## PLANNING REPORT...

Premises        9-11 Argyle Street, Glasgow (14 Stockwell Street entrance)

PROPOSAL: Use of retail premises (Class 1) as flatted development ( 4 units) (Suigeneris) and external alterations

The following is response to the planning comments issued 29.08.22

Client	Woodside PO & Convenience Store Ltd	Address	14 Stockwell Street, Glasgow
Project	COU conversion to studio apartments	Dwg	A1514.22.04
Title	Elevation ... existing	Date	21.06.22
		Scale	1:50

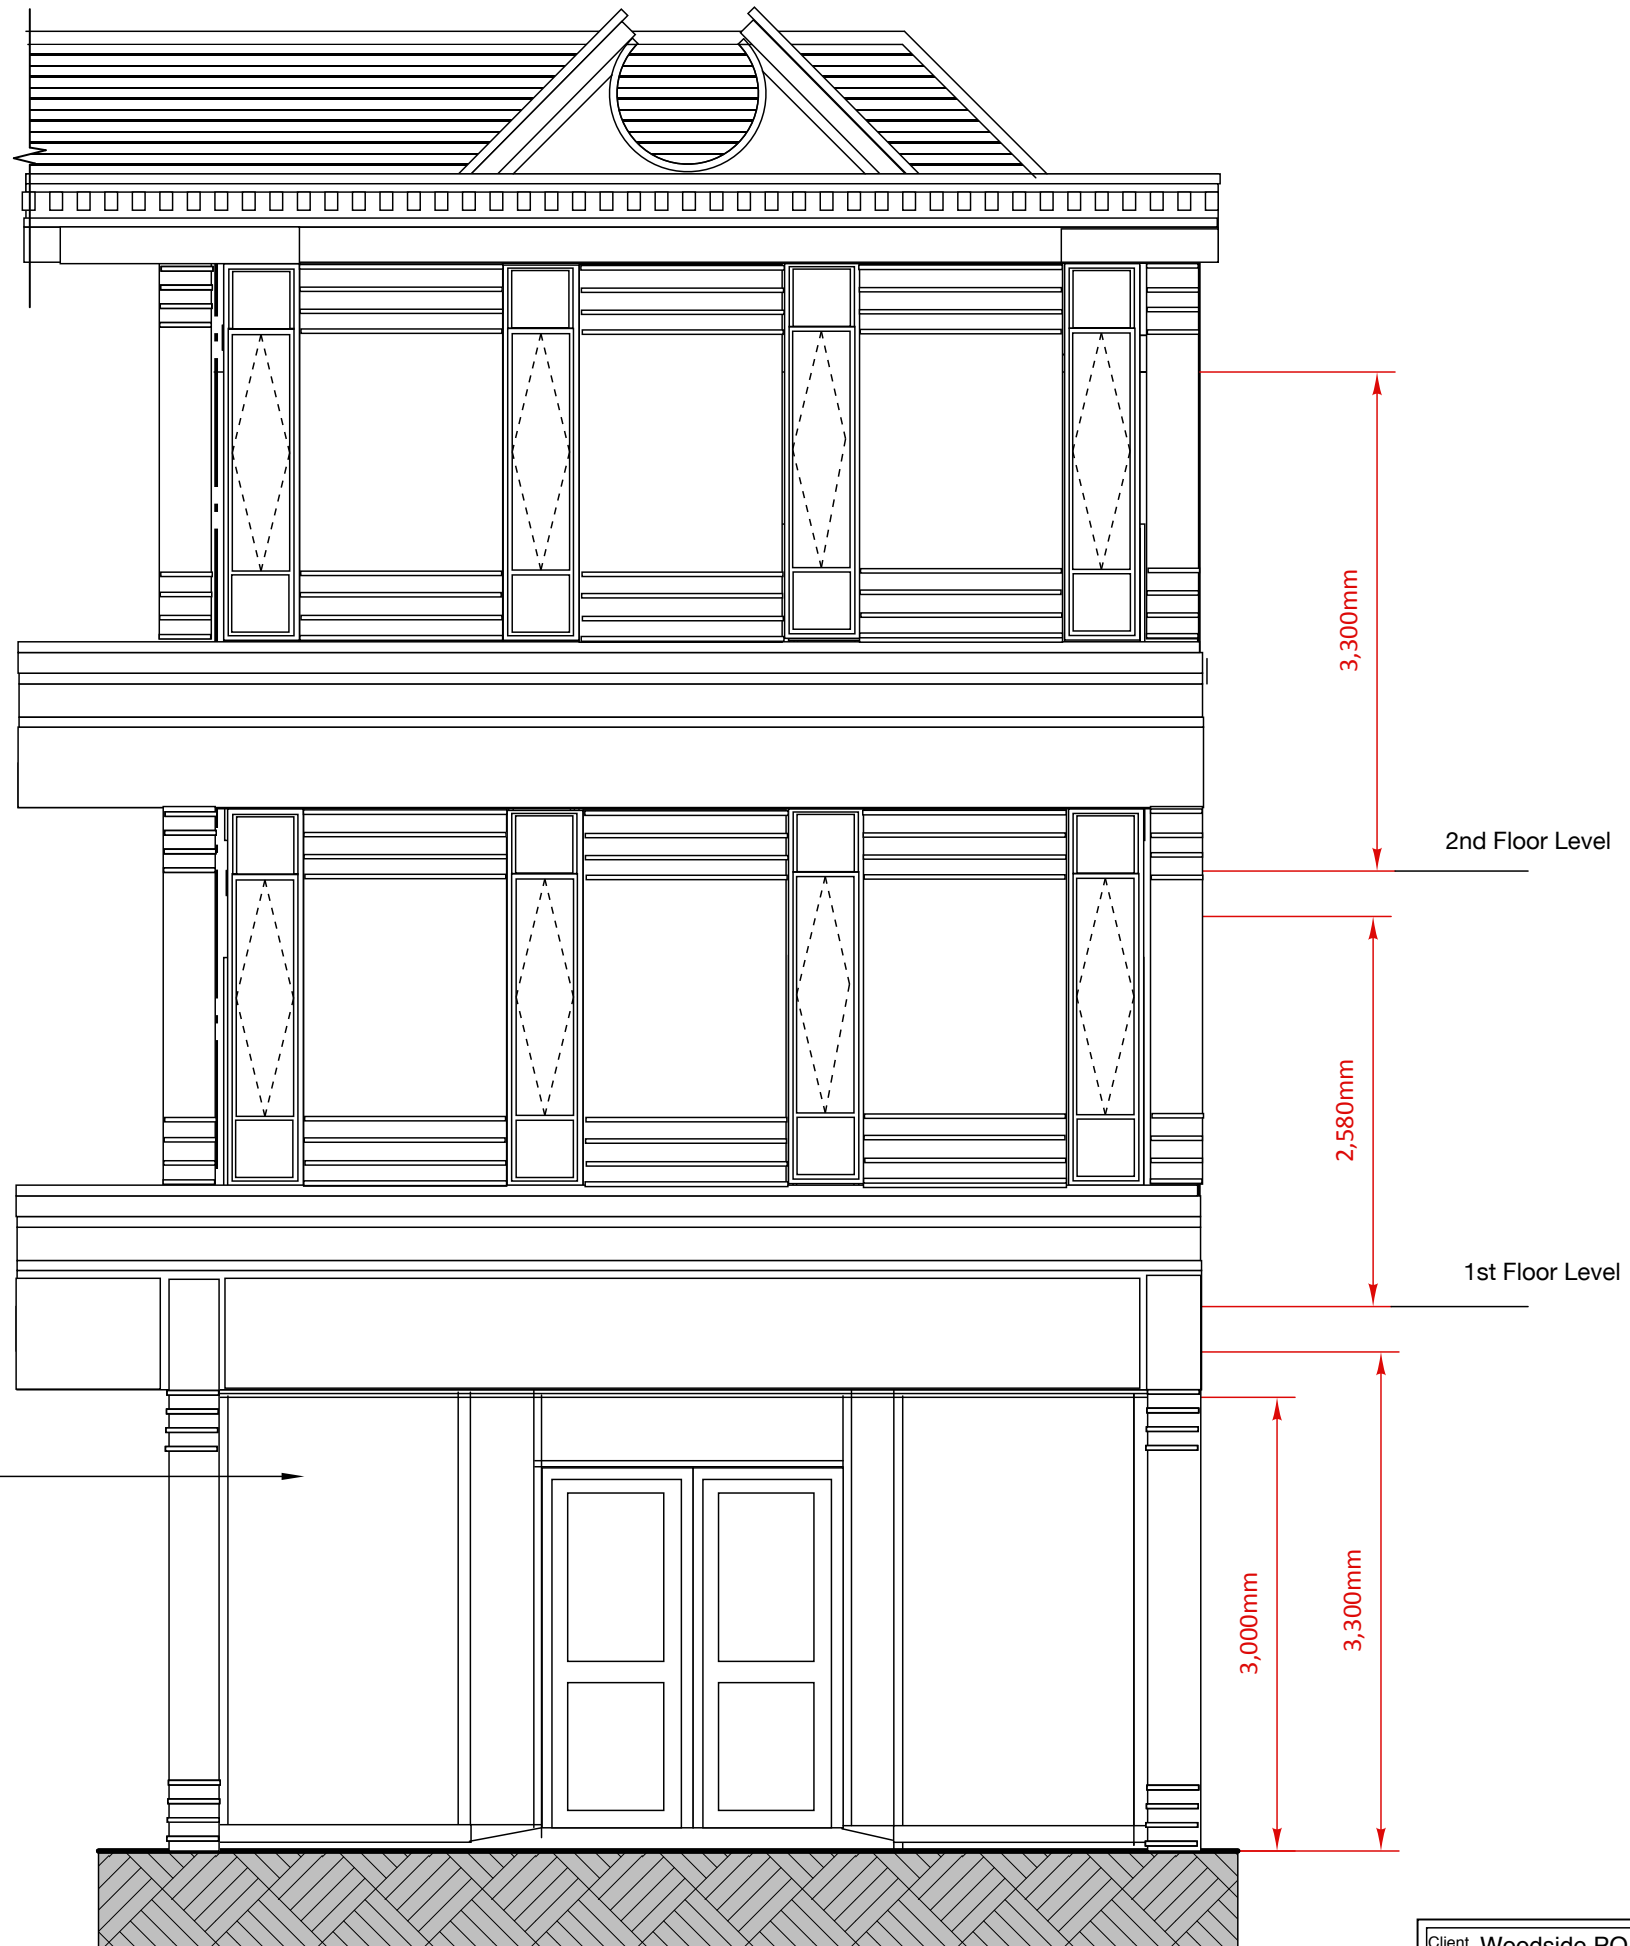
- e)        All walls floor and first floor ceiling are concrete finished . The roof is a pitched roof at front only leading to a flat roof over this and the adjacent corner building which was all built at the same time.

Client	Woodside PO & Convenience Store Ltd	Address	9 - 11 Argyll Street, Glasgow
Project	COU conversion to studio Apartments	Dwg	A1514.22.01
Title	Location & Block plans	Date	22.07.22
		Scale	1:1250, 1:500

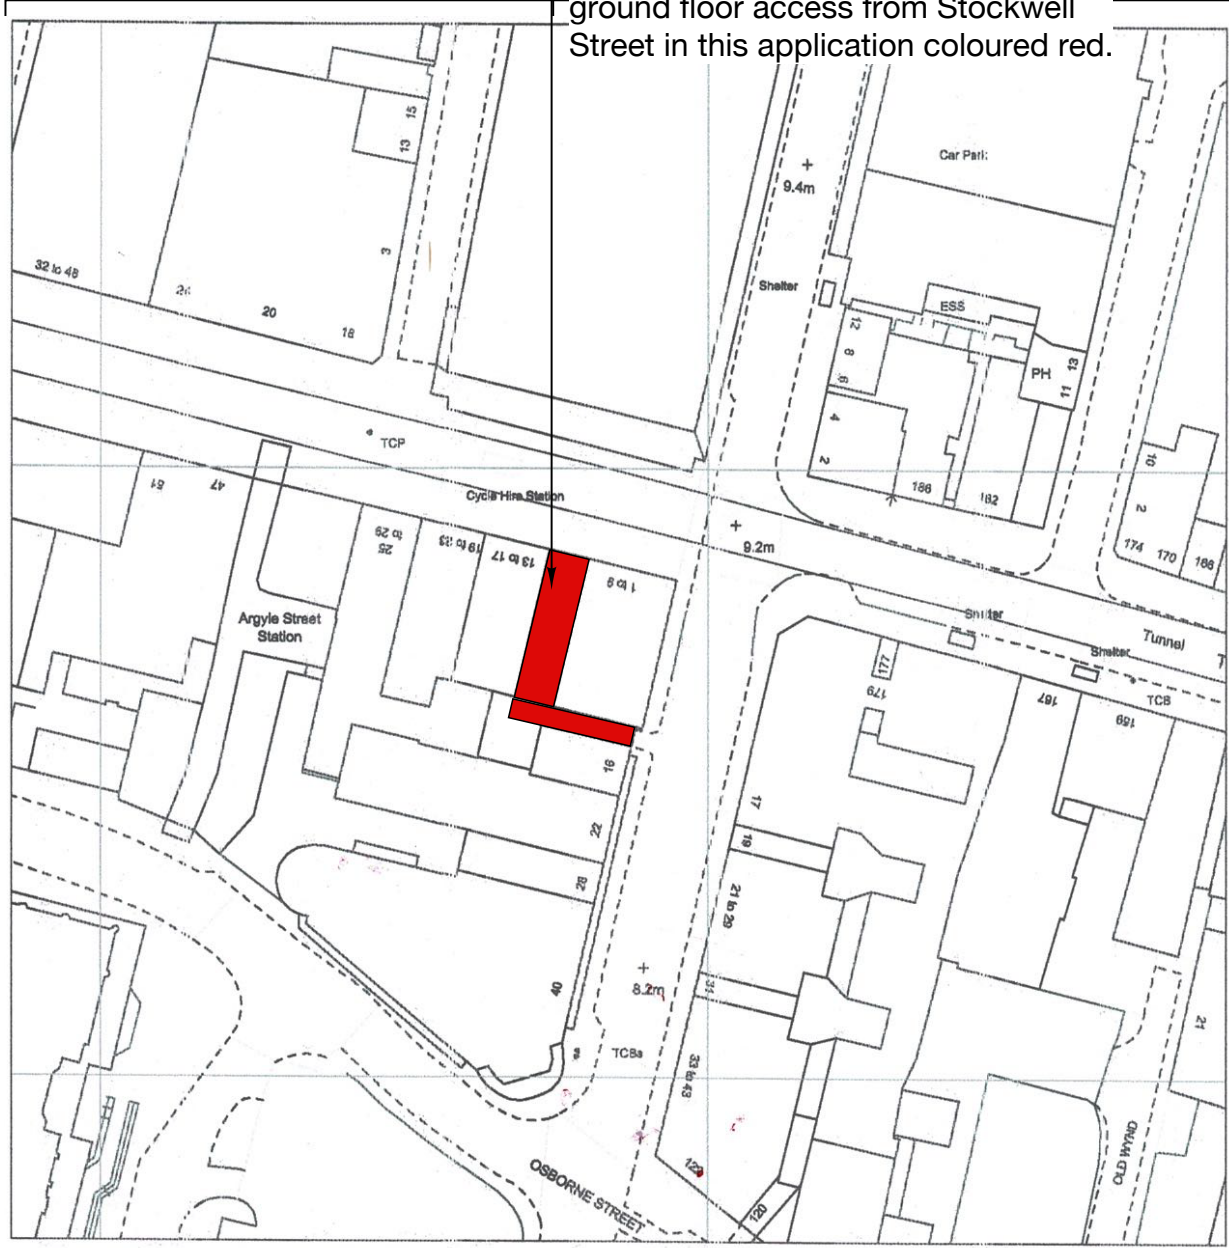
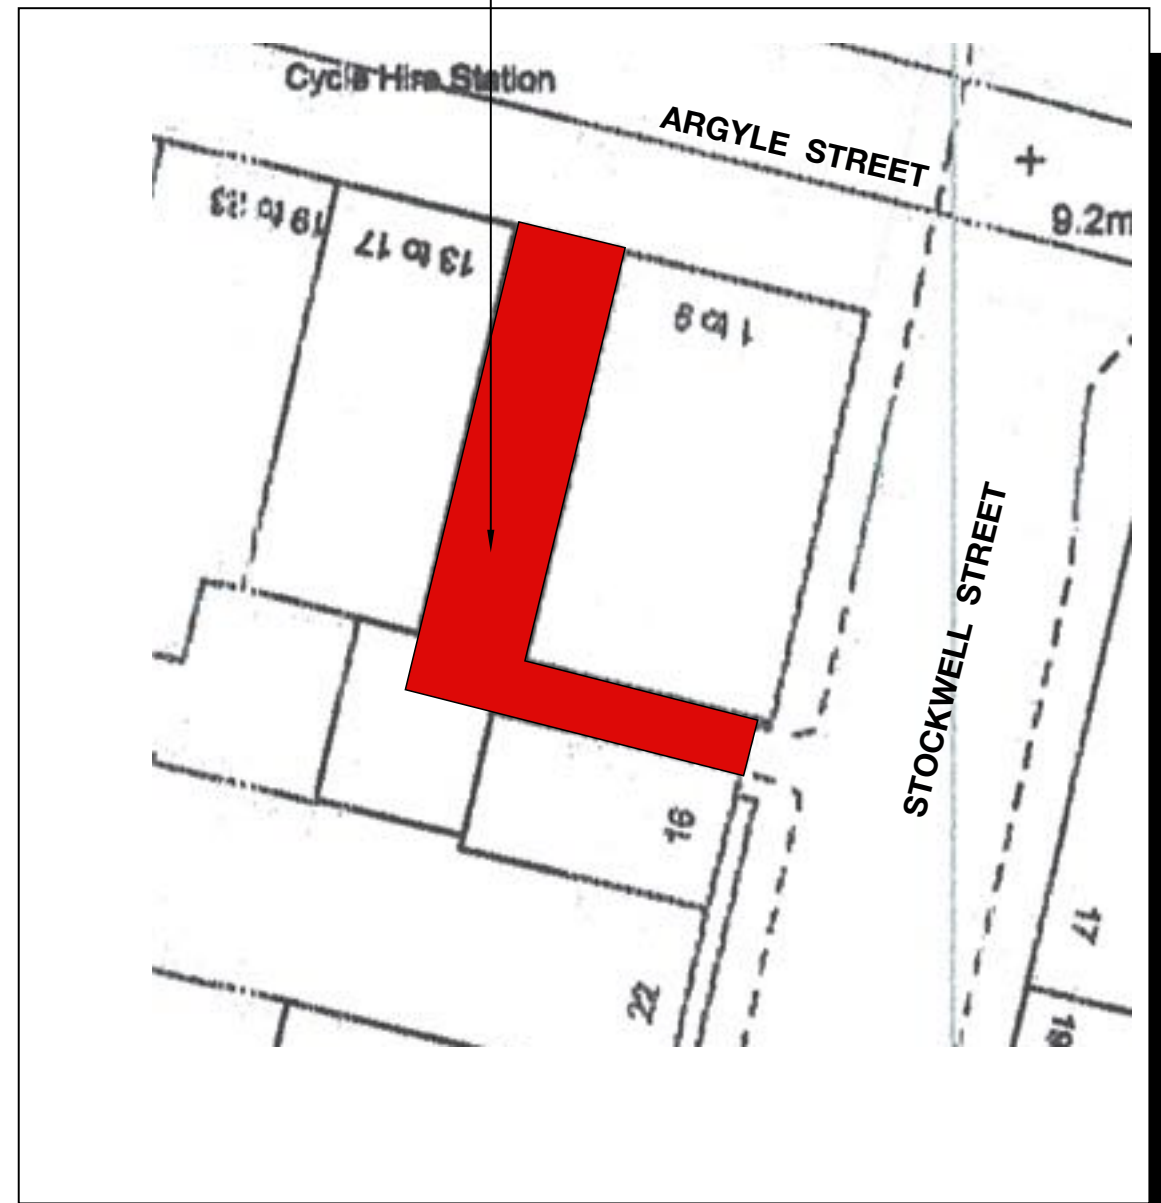
- a)        The direction North is noted on the Location and Block Plan
- b)        Access arrangements...  
Pedestrian access from 14 Stockwell Street as noted on Block Plan.  
There is no landscaping involved as the proposal is on first and second floor levels  
There is no direct vehicular access to the property. And no parking on Stockwell Street.  
Car parking is within 100metres from the property at King Street.  
There is no external drying area at upper floor and there is no drying green beside the property. Flats to be fitted with combined wash/tumble drying facility with no direct extract function.  
Refuse bins will be located internally in the stores available to each flat then moved to the external location on Stockwell Street for removal by Local Authority waste disposal pick up point.  
The flats have connection at Stockwell Street which is the entrance to the proposed accommodation.

- c)        The location and block plans indicate the proposed flatted accommodation position within the fabric of the buildings immediately adjacent to the property with frontage looking onto Argyll Street as the only external wall for the proposal. Provided daylight and ventilation.  
Single pedestrian access and emergency escape is to Stockwell Street entrance.
